Response to Comments, May 17 Email

Response to Comments, May 23 Email

AE101 AE549 SCALE: 1 1/2" = 1'-0"

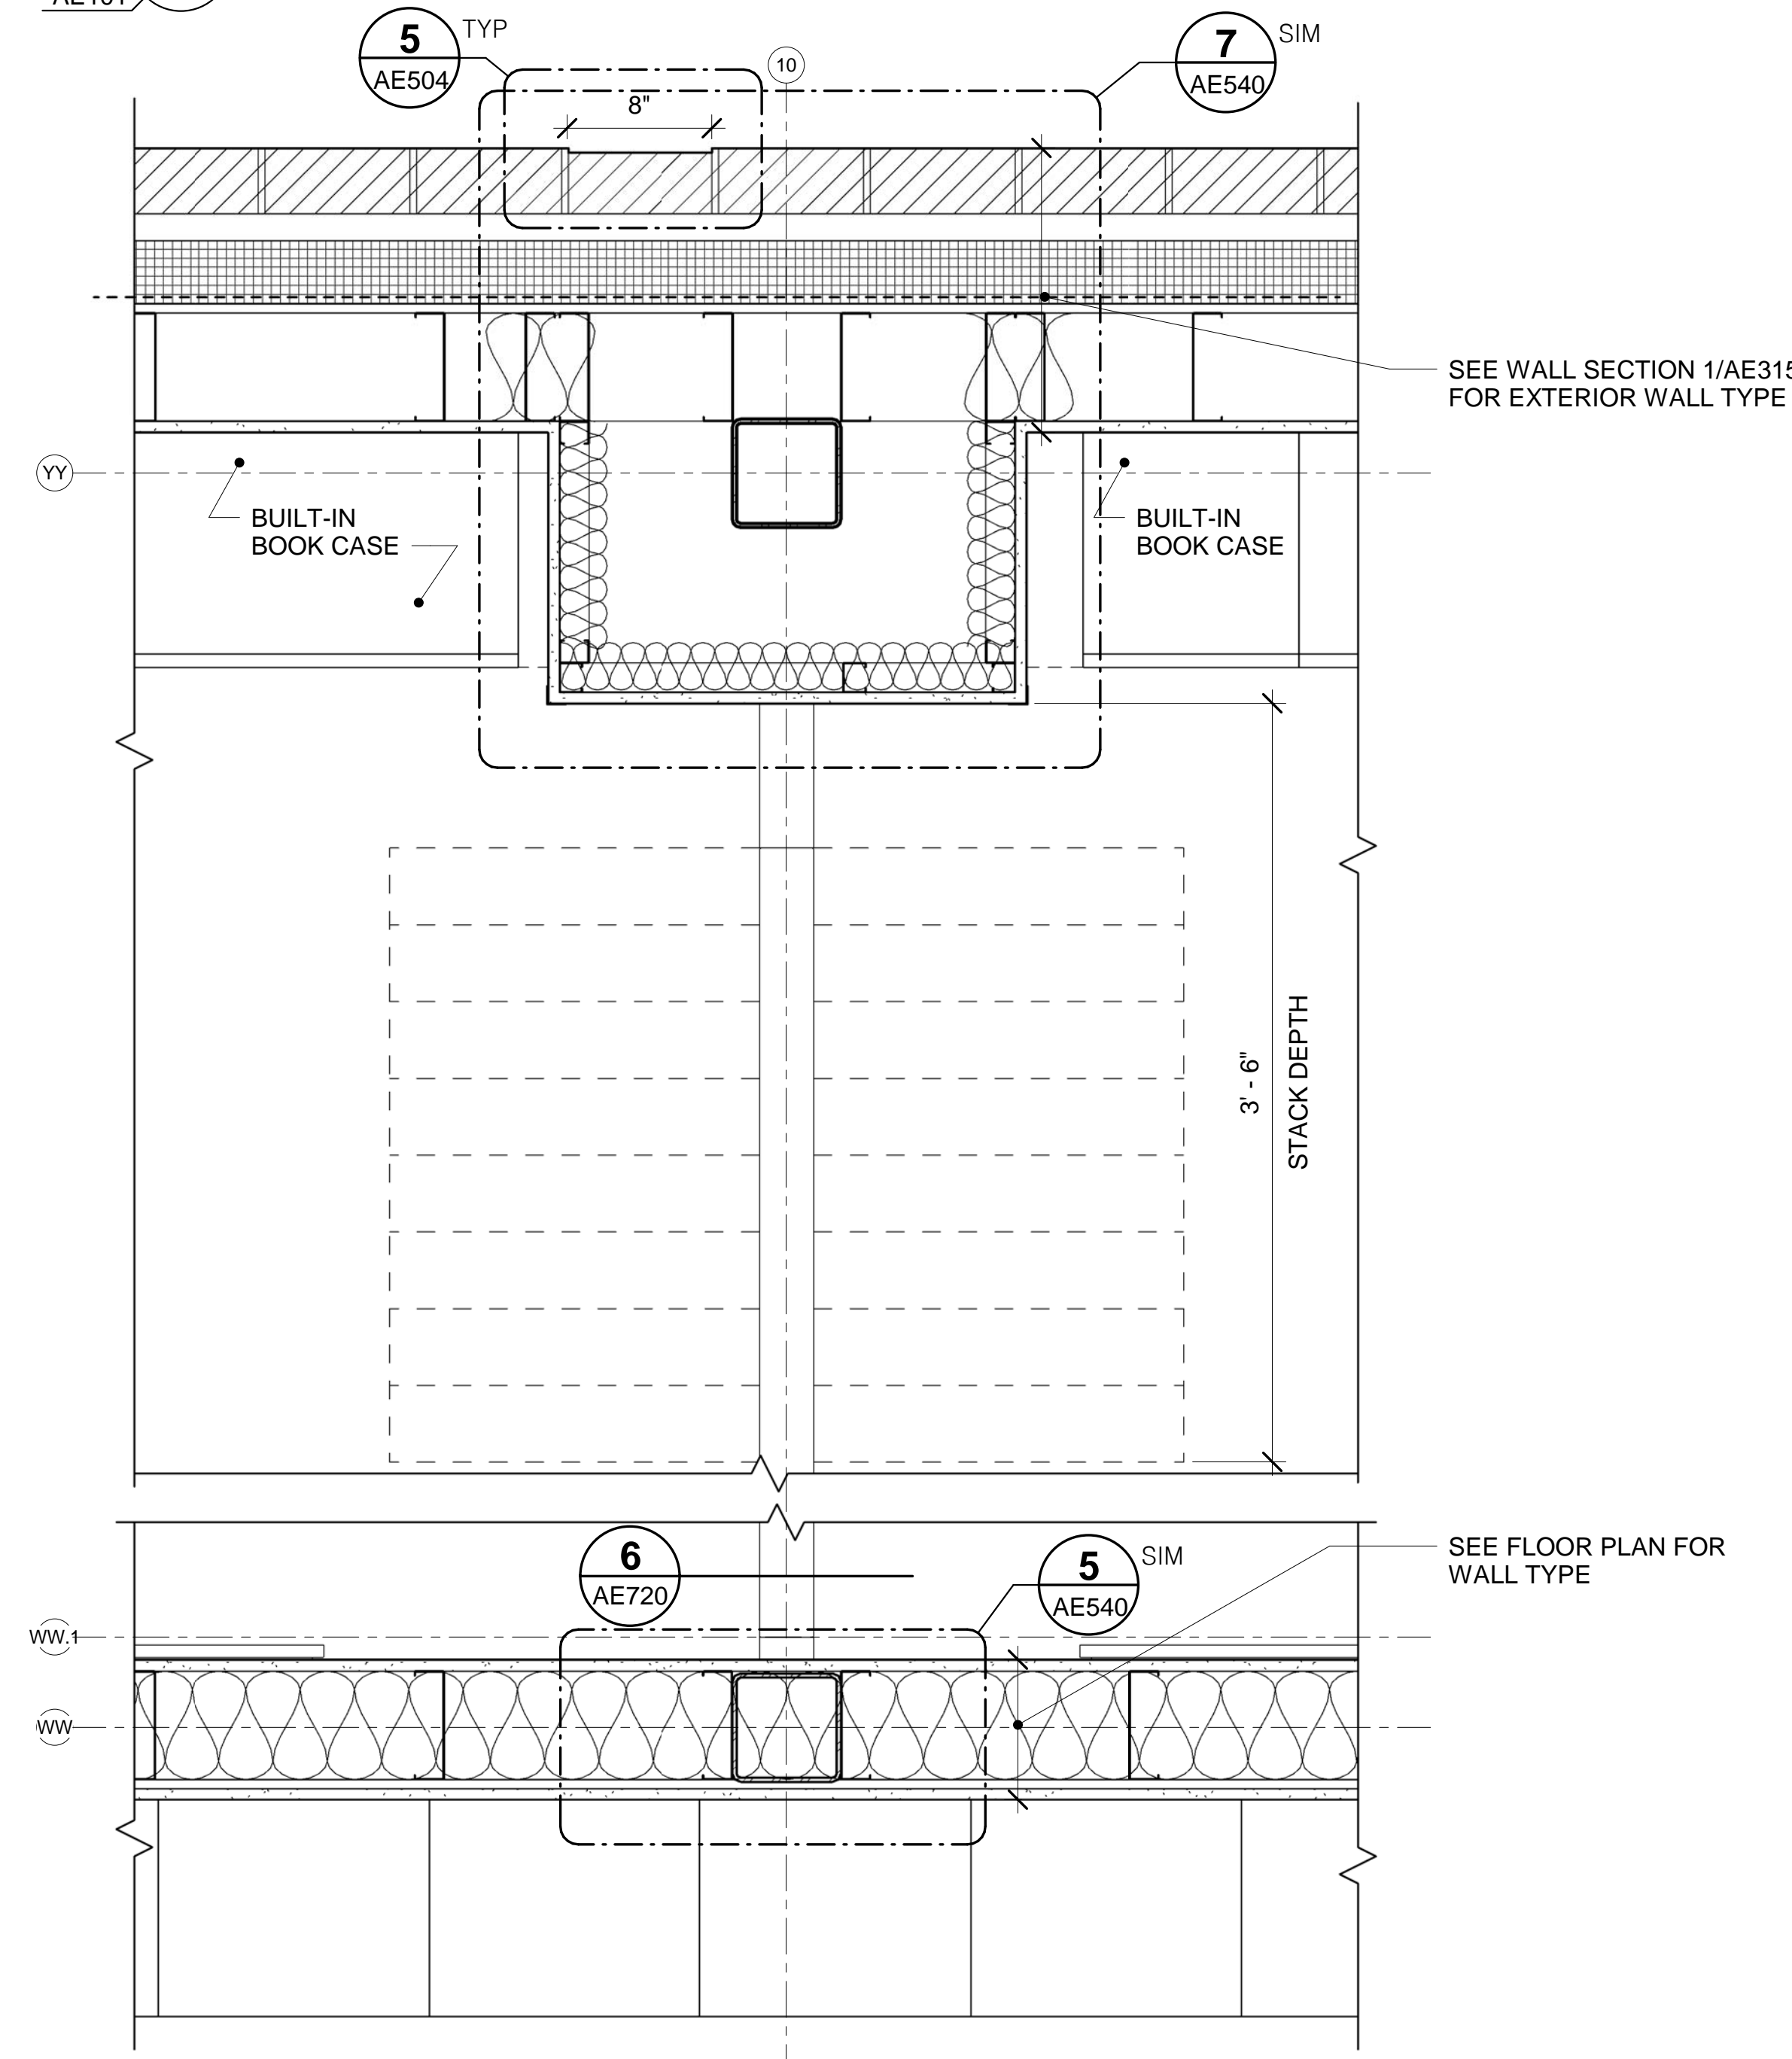
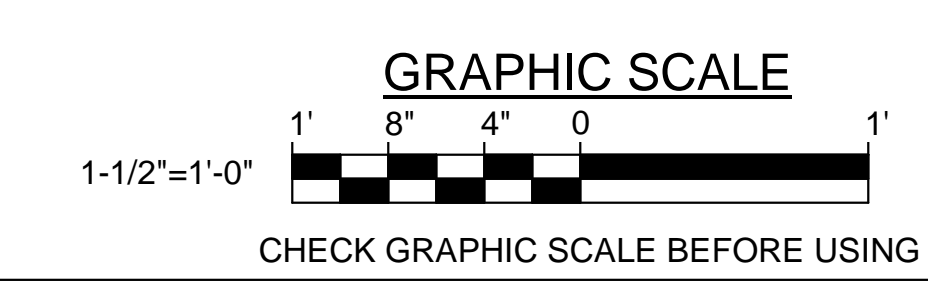
Q: I see that the two lobby areas are shown as fire walls. I do not see where the details are for the extension of these fire walls are called off. Please clarify the intent.

A: Fire wall details are located on sheets AE547, AE548 and AE549.

**1 PHASING AND CONSTRUCTION MANAGEMENT PLAN-PHASE 1**  
 CP101 SCALE: 1"=50'

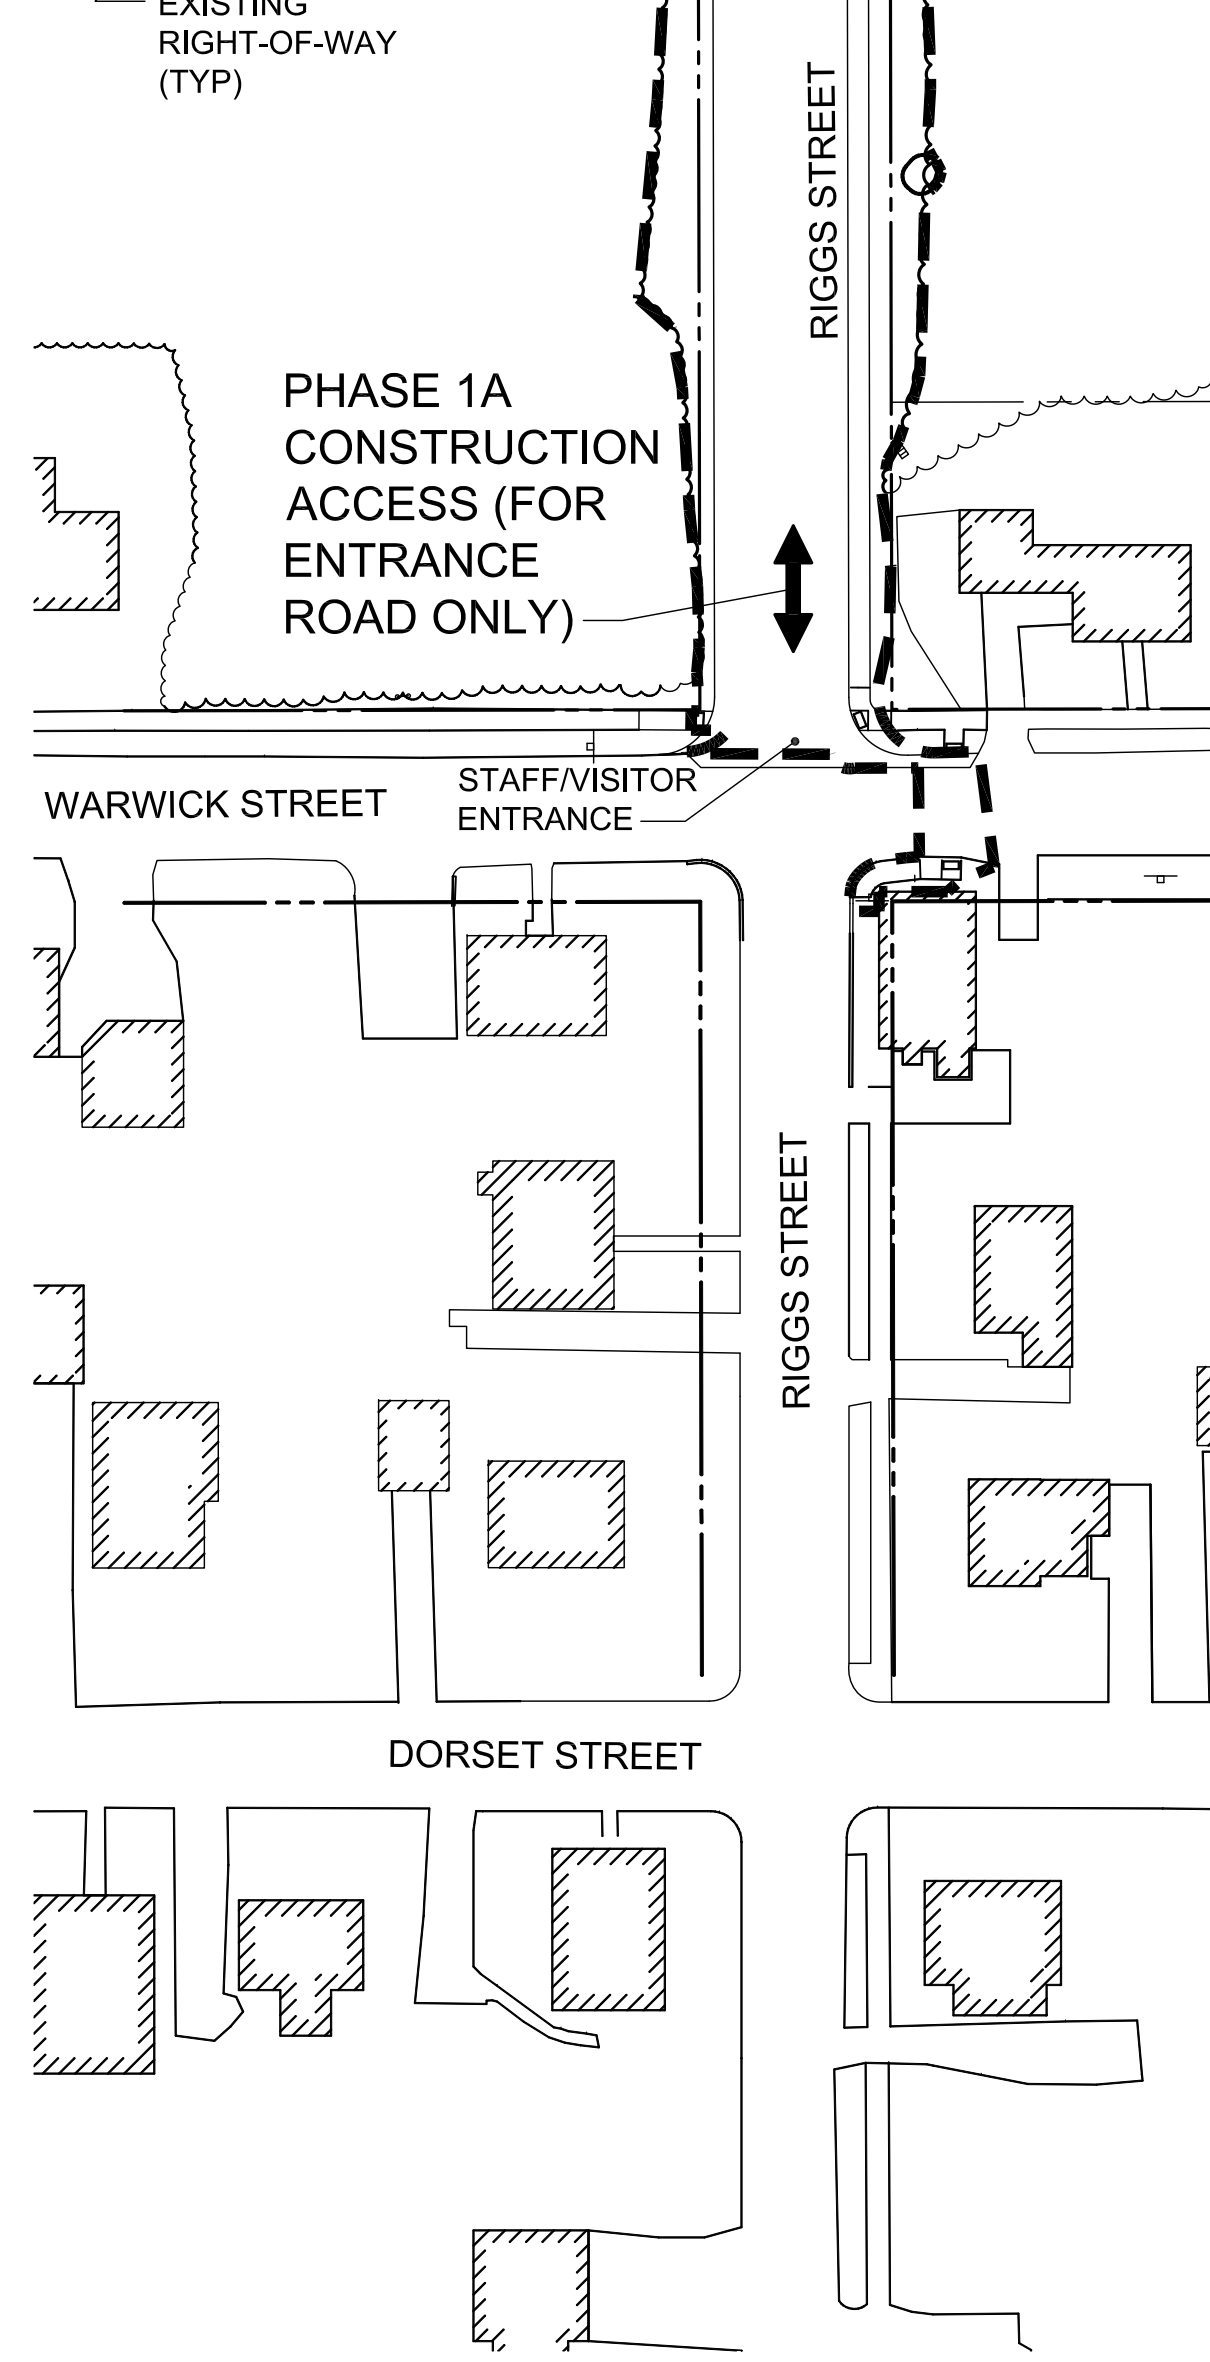
4. Provide a phasing for demolition/construction/occupancy document with associated timeframes each phase work is expected to be completed.

Answer: The phasing plans/schedule are indicated on sheets CP101 and CP102.

**1 EGRESS AND FIRE RATING FIRST FLOOR PART PLAN WING A**  
SCALE: 1/8" = 1'-0"

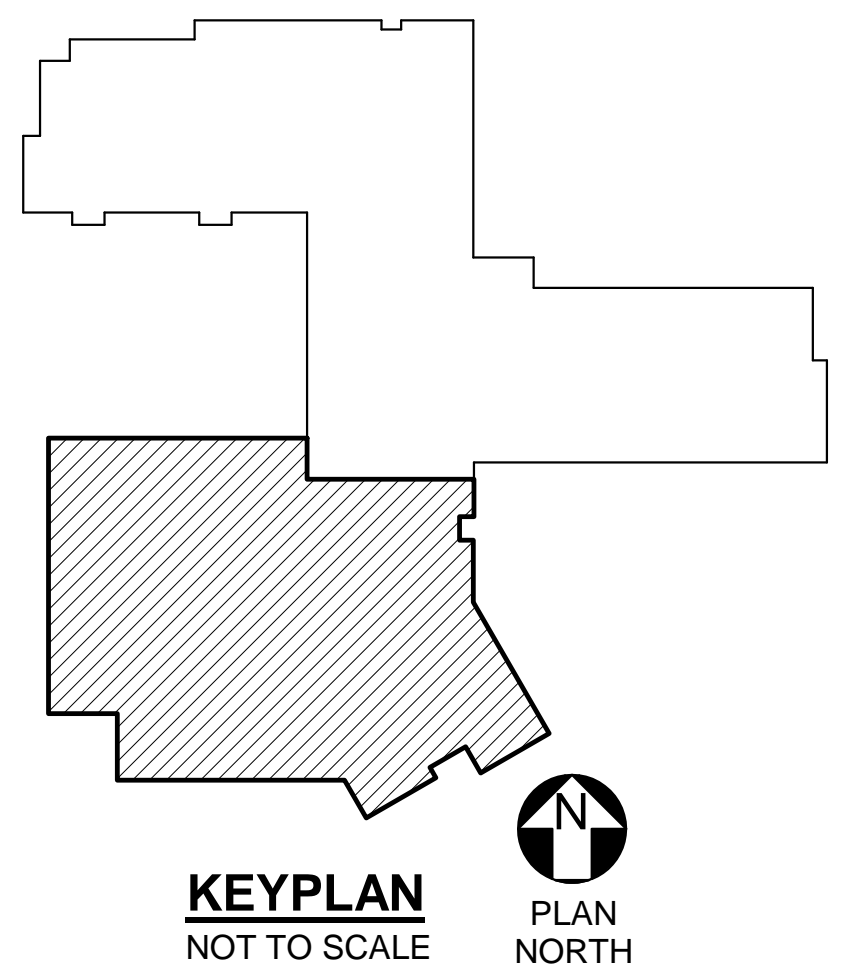
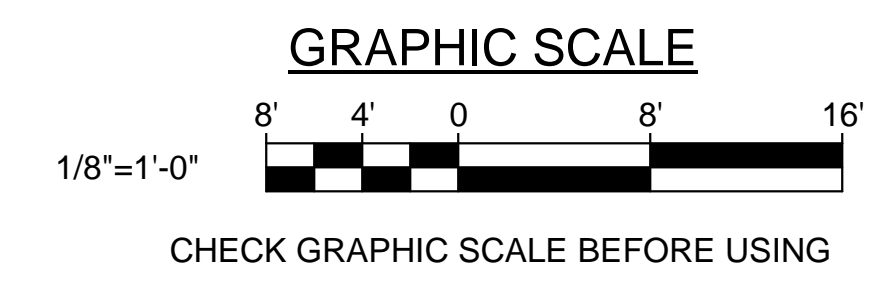
Q: This area is referenced as temporary refuge. The code references an “area of refuge”. Is this what you are referring to?

A: This is in reference to a “Refuge Area” under IBC, Section 1025.4. The word temporary was used per the NFPA 101 handbook discussion on this type of space.
